21 March 2024

Subject: SSD-29508870: Request for additional information

I refer to your letter dated 15 February 2024 in relation to a request for additional information associated with the *Birriwa Solar and Battery Project - Amendment Submissions Report*.

BARNEYS REEF ROAD UPGRADE

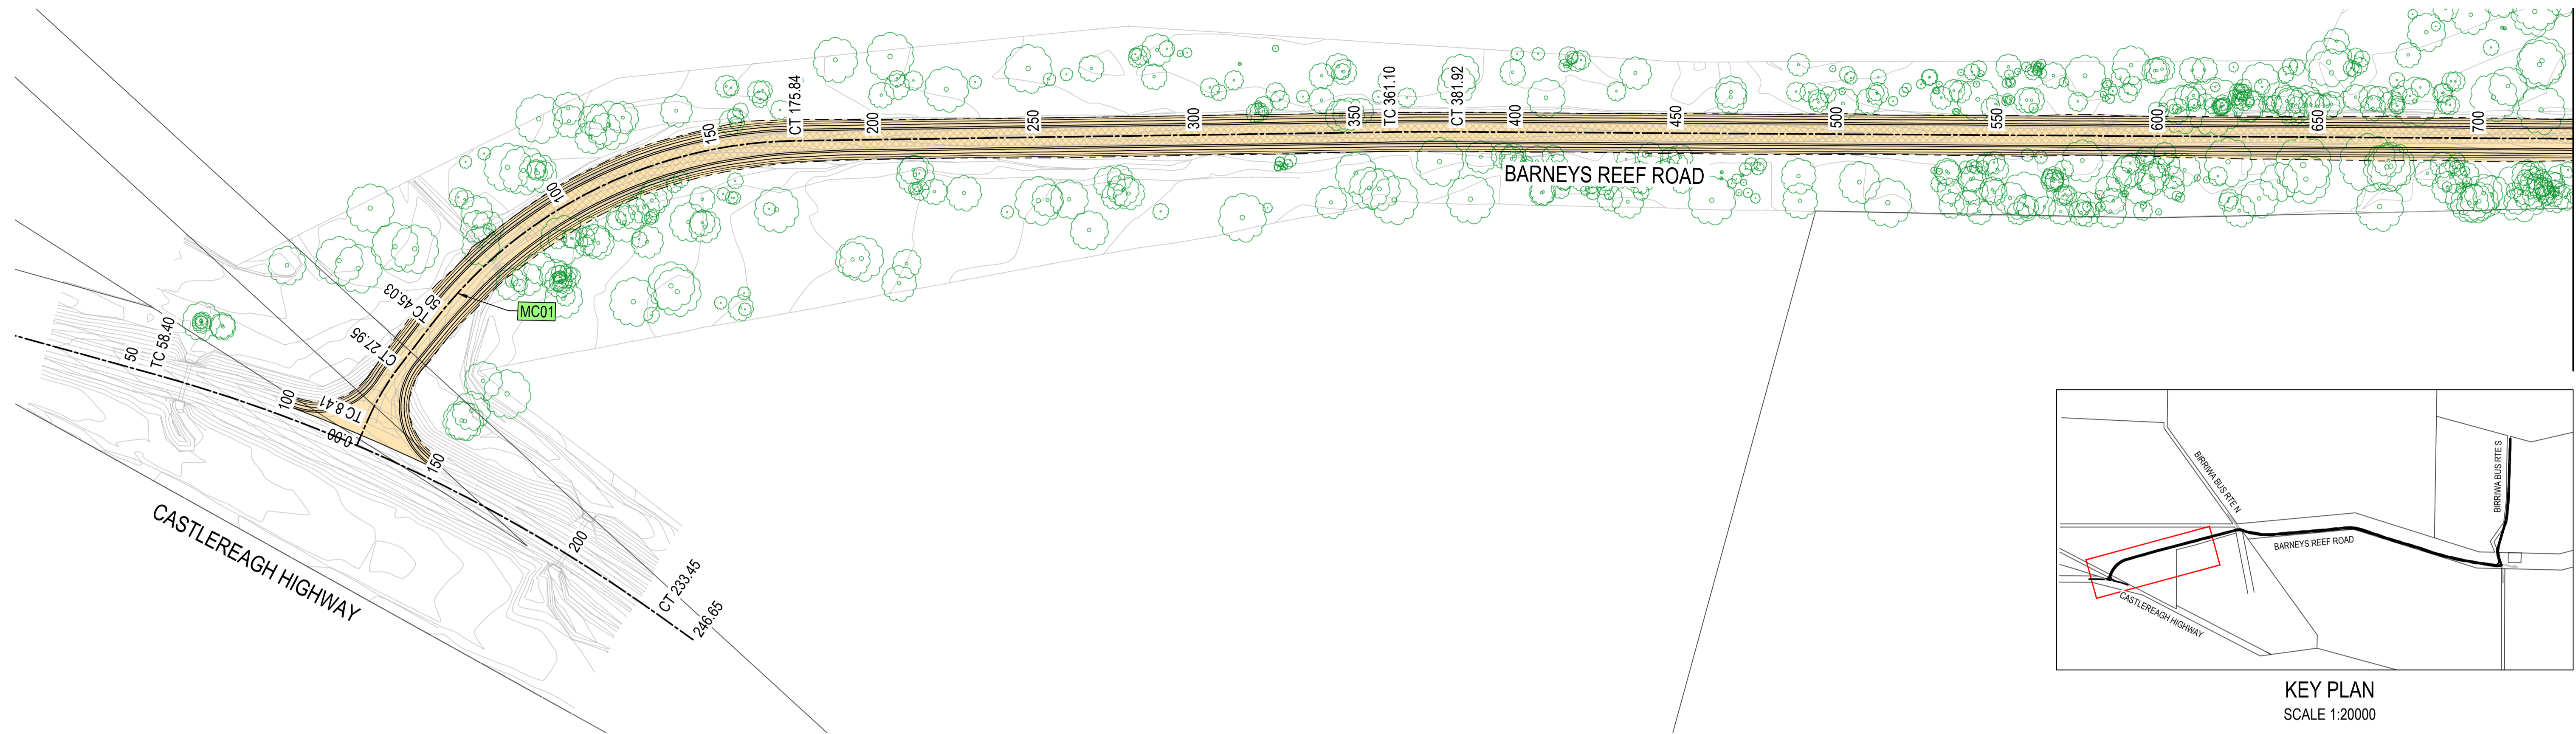
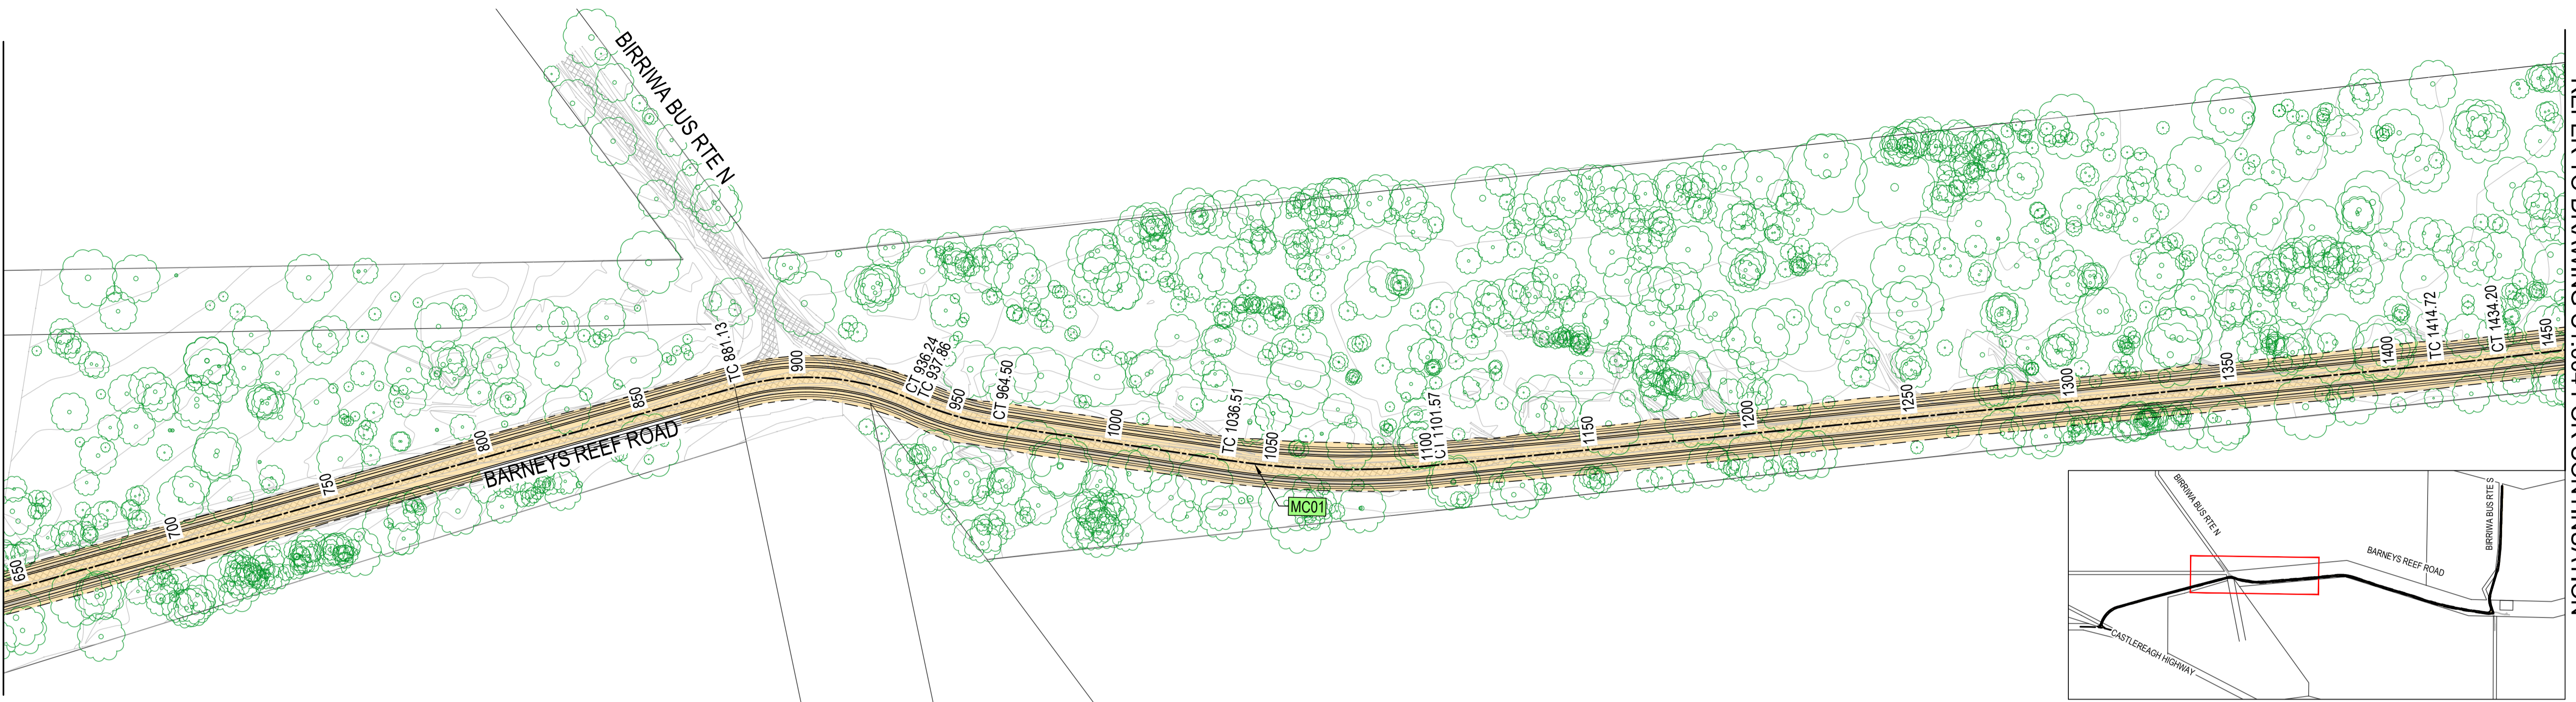
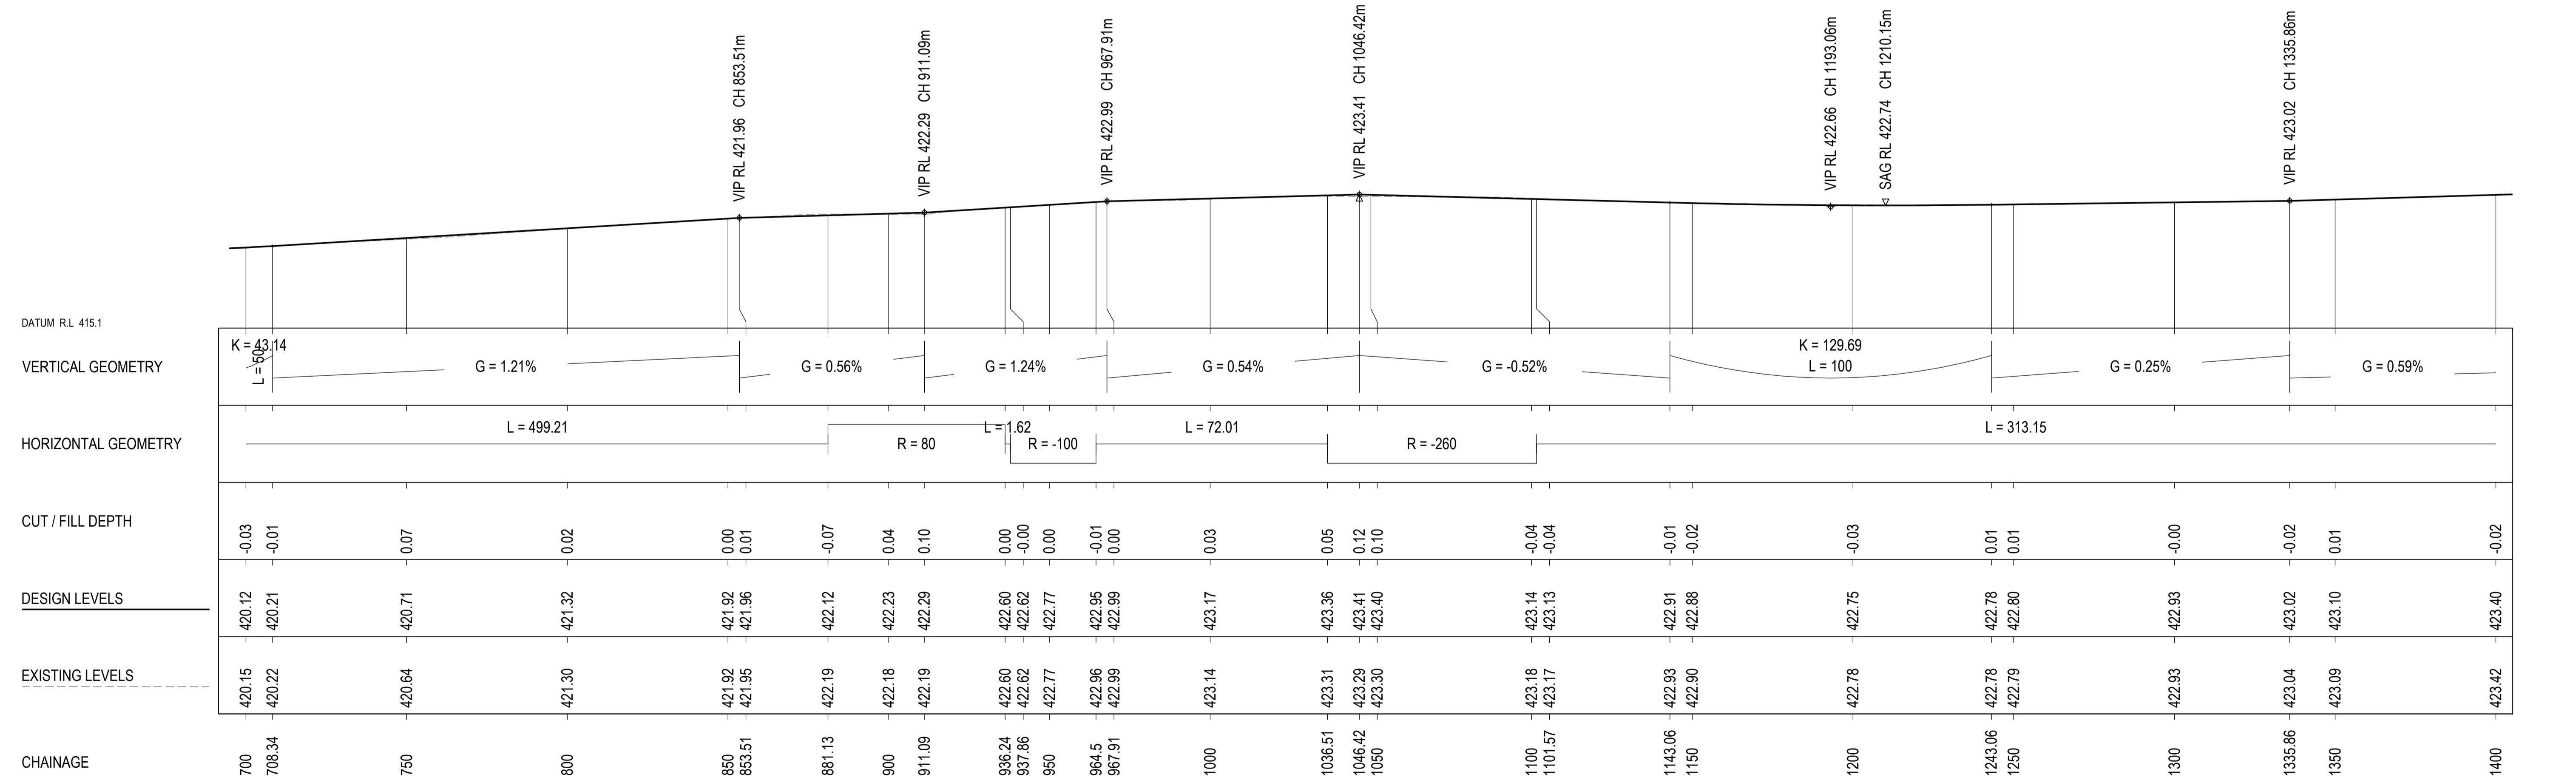
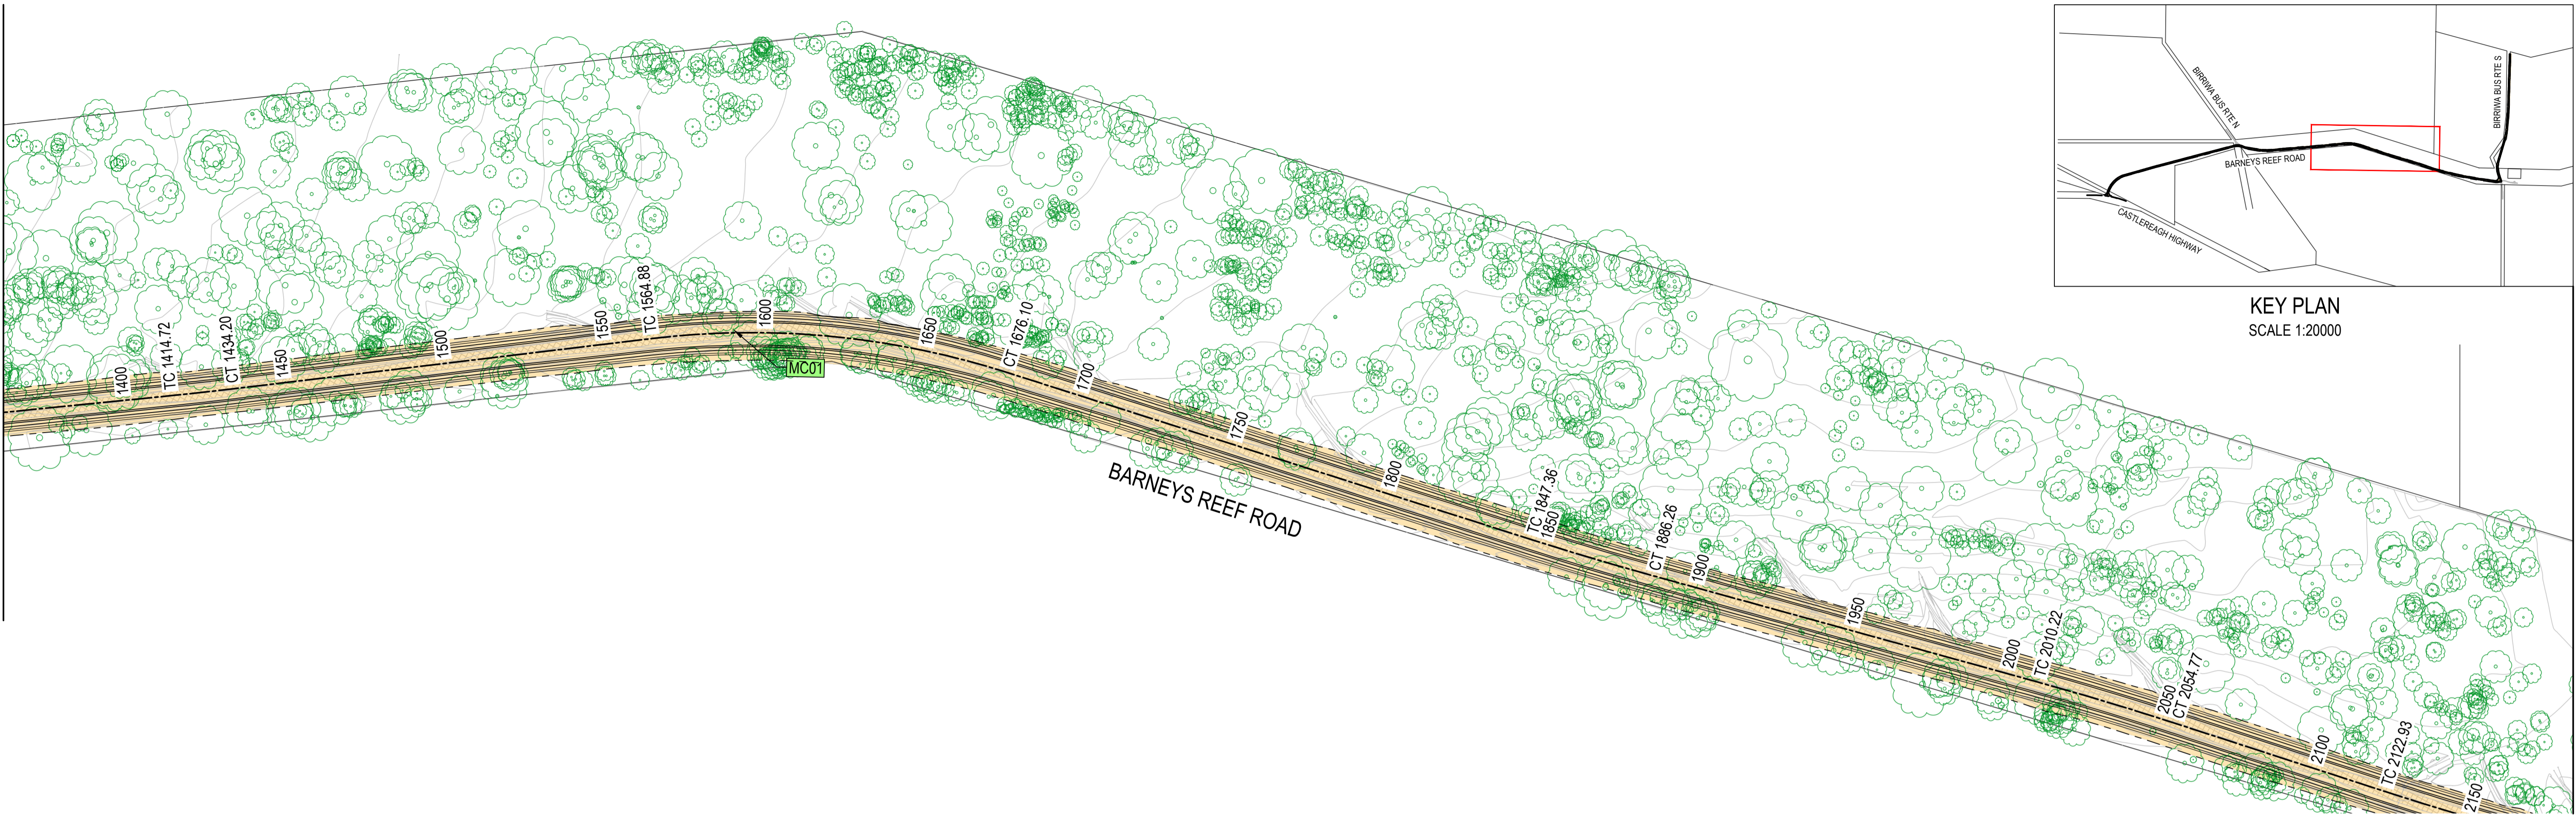
e) As discussed in the body of the letter; Regarding the intersection at Castlereagh and Barneys Reef Road (and will likely be required for Birriwa Bus Route Road/Castlereagh Highway), a 1m centre line and 2.5m shoulders are required to be provided in the revised strategic design for vehicle breakdown, or adequate width verge verified on design with 2.0m shoulder to allow a stationary vehicle to park clear. Provision of	TfNSW confirmed at a meeting on 7 March 2024 that 3.5 m lanes, 2 m sealed shoulders with 1 m verge, totalling 13 m carriageway width will be required with consideration of 6:1 batter within the road reserve. The strategic concept design (Appendix A) complies with the above requirements on the Castlereagh Highway. As per TfNSW requirements, SISD assessment was undertaken based on Figure 3.2 Austroads Part 4a: Unsignalised and Signalised Intersections at a driver's eye height of 1.25 m from the road level.

Feedback	Response
sight lines for SISD from driver eye height to target is also to be included in the strategic design.	
f) Strategic plans provided will need to verify the need for protection of culverts nearby to the intersection. The plans provided do not show all culverts surrounding the intersection.	The strategic concept design shows the locations of culverts in close proximity to the Castlereagh Highway/Barneys Reef Road intersection. Following the meeting with TfNSW on 7 March 2024, TfNSW confirmed that an assessment of culverts/bridges as part of the OSOM assessment is not required at this stage.

Fe	edback	Response
	refugee island as a part of the revised TIA.	
Po	ints of Clarification	
a)	Clarification on the extent of the use of Birriwa Bus Route to access the development. Strategic Design drawings are to be provided for any works proposed on the Birriwa Bus Route.	Birriwa Bus Route South will be to access the development between Barneys Reef Road and the site access. The total length of Barneys Reef Road to be used by the project is approximately 2.5 km. The total length of Birriwa Bus Route South is approximately 828 m. The strategic concept design drawings have been provided in Appendix A.

c) Effects of the development on adjoining property The property boundaries are shown in the strategic concept design (Appendix A). The plans show that works associated with the road upgrade on the eastern side of the Castlereagh Highway will encroach on Lot 7300 DP1149875 (Crown Land). Landowner's consent has been obtained for this Lot from Crown Lands.

Feedback	Response
boundaries surrounding the intersection must be included to highlight potential boundary issues.	
d) Property boundaries in relation to extents of development are to be demonstrated in detailed design.	The property boundaries are shown in the strategic concept design (Appendix A).
